An
Bord
Pleanála

Inspector's Report ABP-318223-23

Whether the construction of a conservatory, 3 no. structures and an access track is or is not development and is or is not exempted development.

Lettergesh East, Renvyle, Co. Galway

Former cottage
reroofed as
greenhouse.

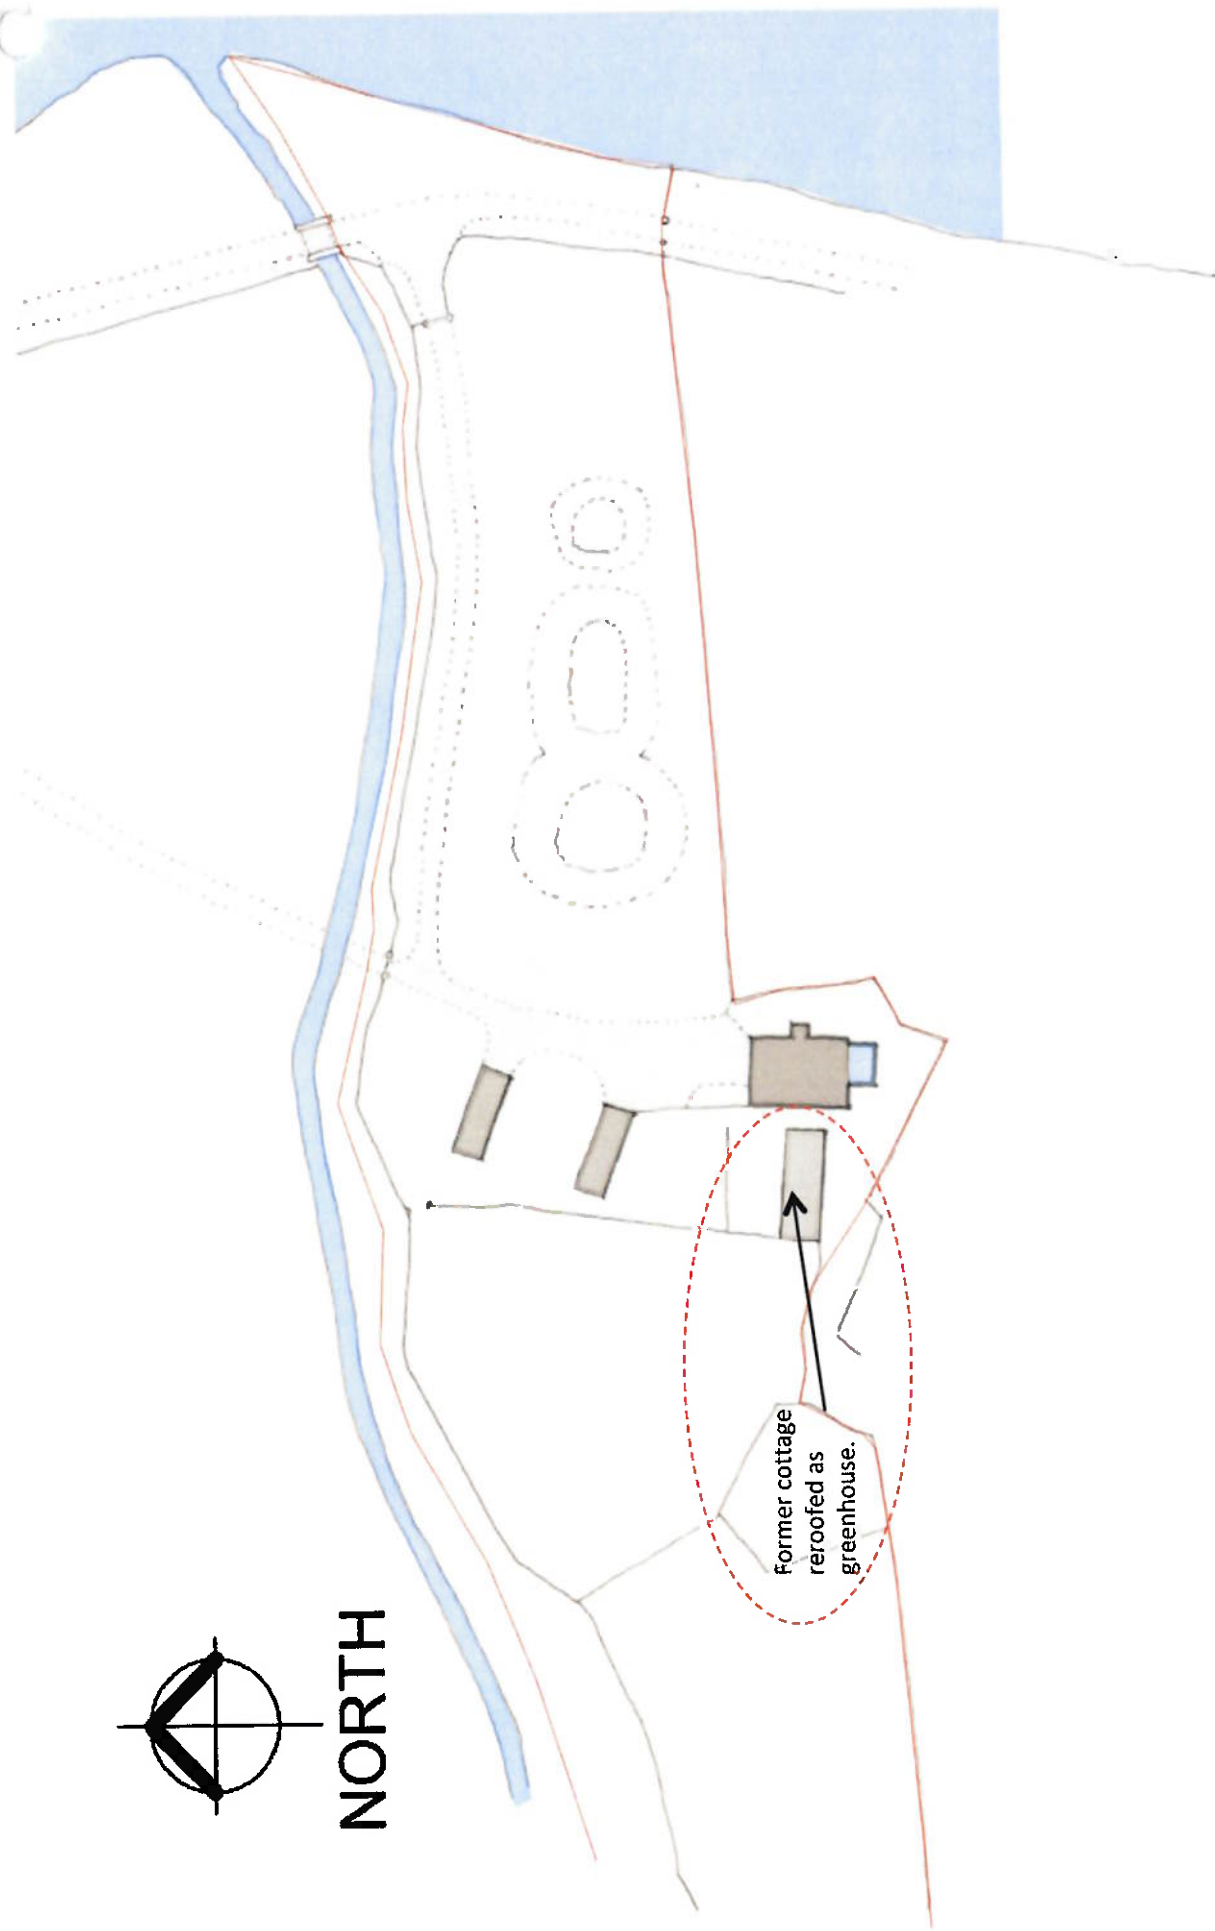
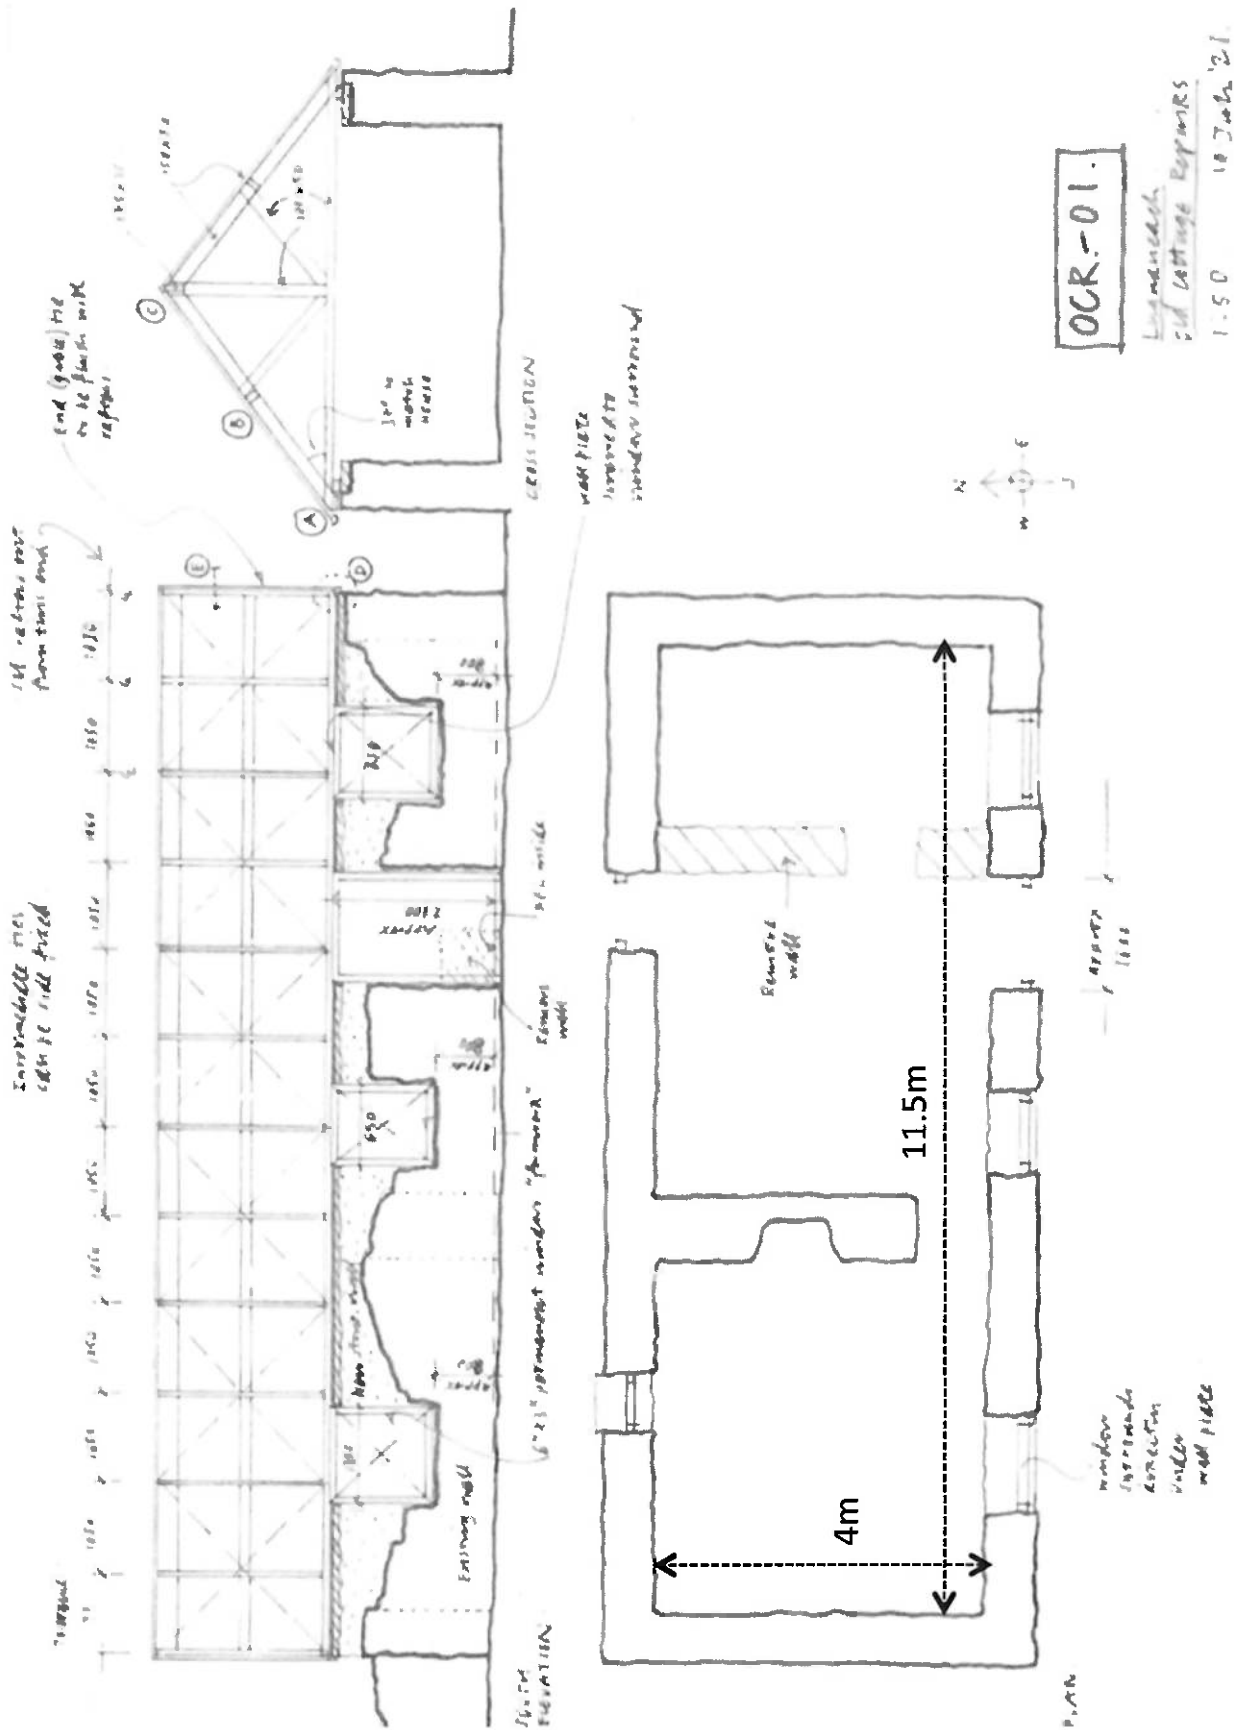
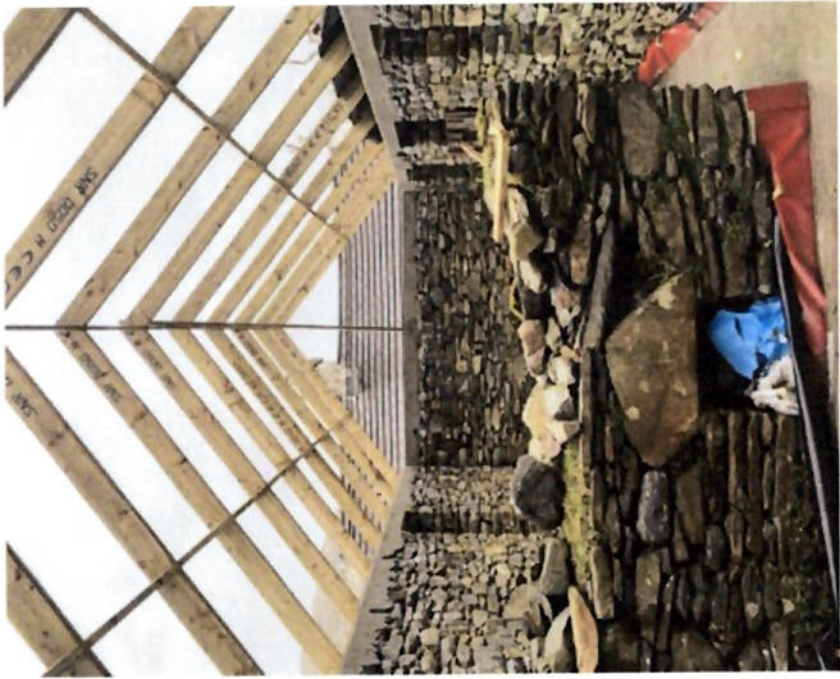
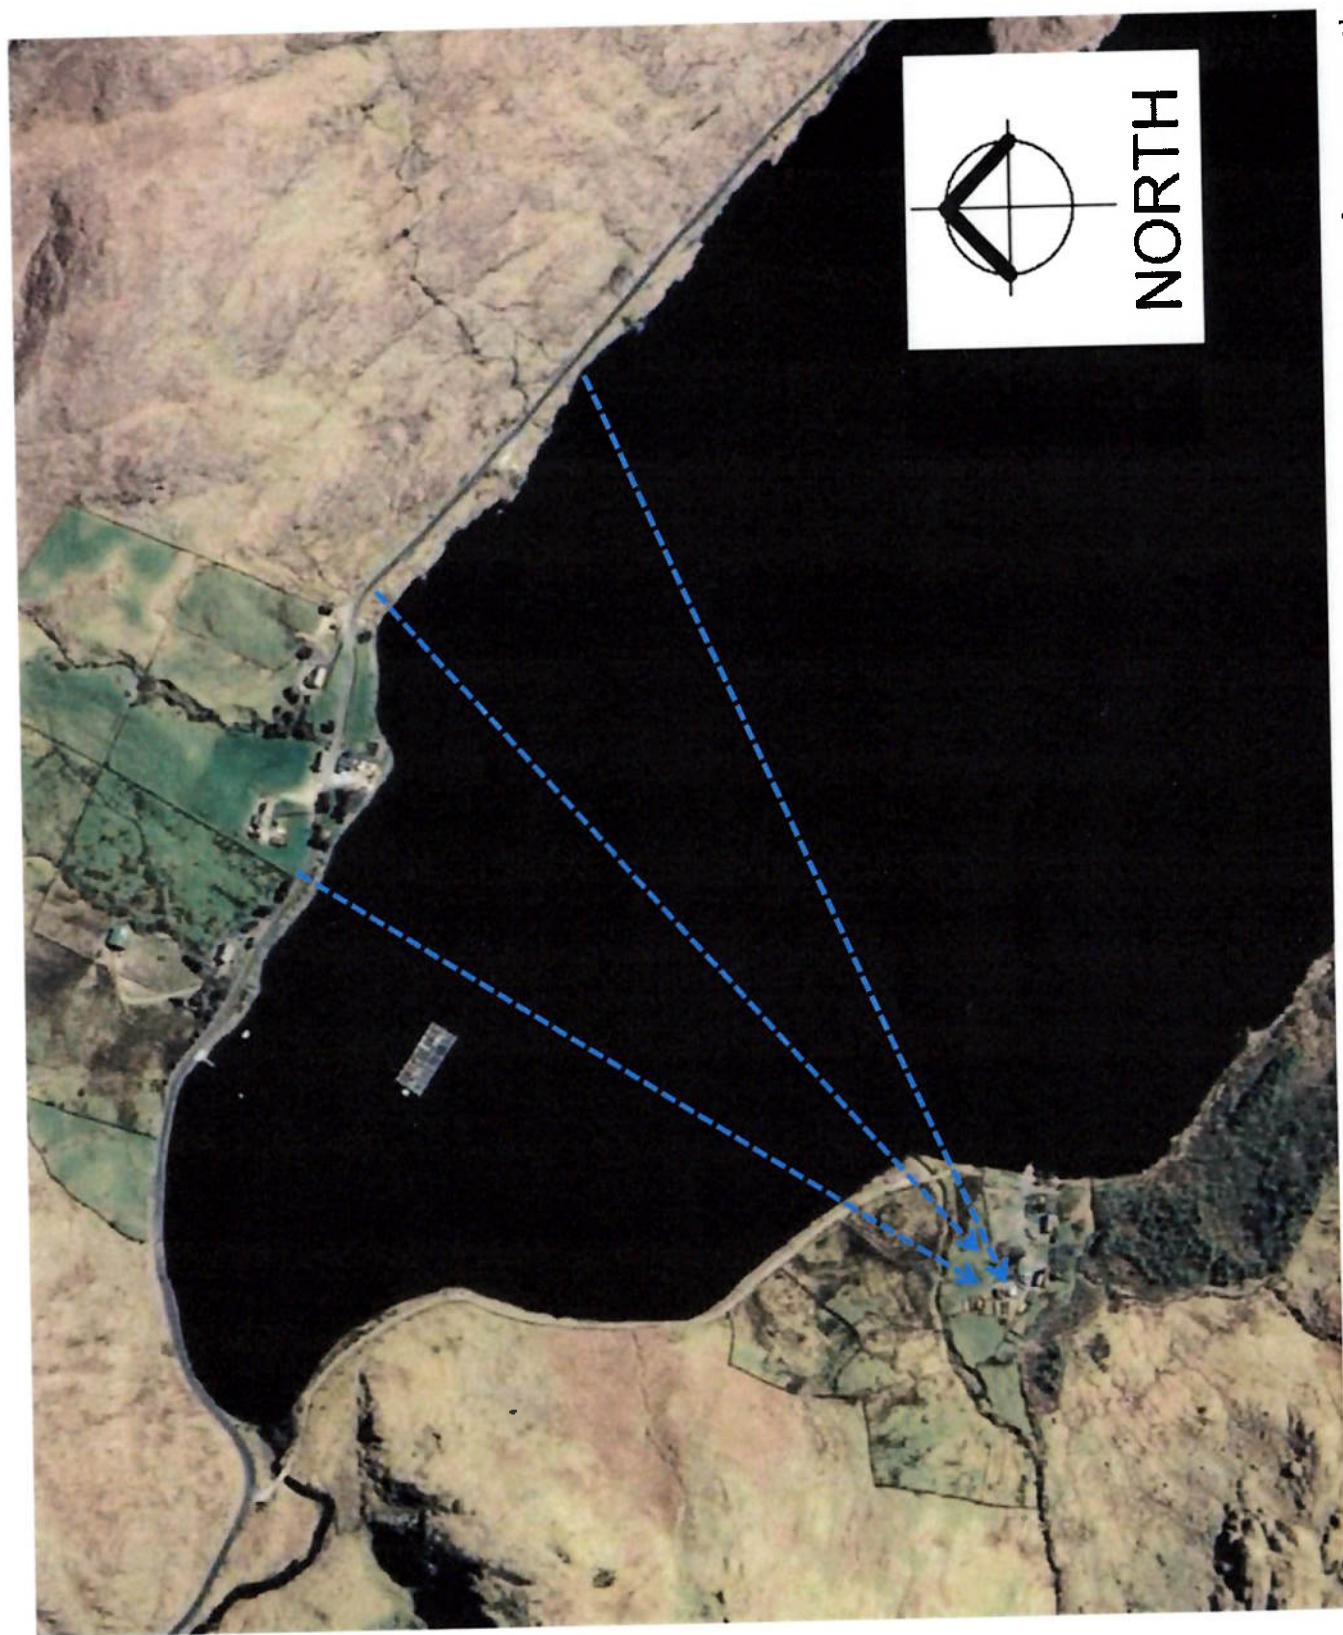
¹ From comparing a photograph of the structure indicated as 'stone shed/former cottage' submitted with the referral to the PA it is apparent that in addition to the structure being reroofed the external and internal walls have also been built up. The particulars submitted also indicate the removal of an internal wall. The AA Screening report submitted to the PA also refers to the wall plate of the structure having been 'repaired to original dimensions'.

8.4.3. **Building up of external and internal walls, the removal of an internal wall, and the provision of a Perspex roof on a ruinous structure, previously used as a shed/cottage** – the works undertaken to the structure indicated as ‘former cottage in ruin’ comprise the building up of the side wall of the structure as indicated on *Drawing No. OCR-01*, the removal of an internal wall and the provision of a Perspex pitched roof. The referrer contends that the provisions of Section 4 (1) (h) of the Planning and Development Act, 2000, as amended confer an exemption of these works. Section 4 (1) (h) provides for ‘*development consisting of the carrying out of works for the maintenance, improvement or other alteration of any structure, being works which affect only the interior of the structure or which do not materially affect the external appearance of the structure so as to render the appearance inconsistent with the character of the structure or of neighbouring structures*’. In my opinion the works to the external and internal walls of the structure would come under Section 4 (1) (h), being works for the improvement of the structure, and which in the case of the removal of the internal wall affect only the interior of the structure. The building up of the outer wall does not materially affect the external appearance of the structure, but rather provides for the restoration of the structure to its prior condition. The provision of the Perspex roof, whilst works for the improvement of the structure, would in my view be inconsistent with the character of the structure itself. Whilst I agree with the referrer’s contention that the roof of the original structure may have changed over time I note that the use of a modern material like Perspex would not have been used and is therefore inconsistent with the original design of the structure. Additionally, the

transparency of the material is in my opinion incongruous with the design idiom of the structure.

In summation, I consider that the building up of external and internal walls and the removal of an internal wall of the conservatory comes within the scope of Section 4 (1) (h) of the Planning and Development Act, 2000, as amended and **is exempted development**, but that the provision of a Perspex roof does not come within the scope of the exempted development provisions of Section 4 (1) (h) of the Planning and Development Act, 2000, as amended and **is not exempted development**.
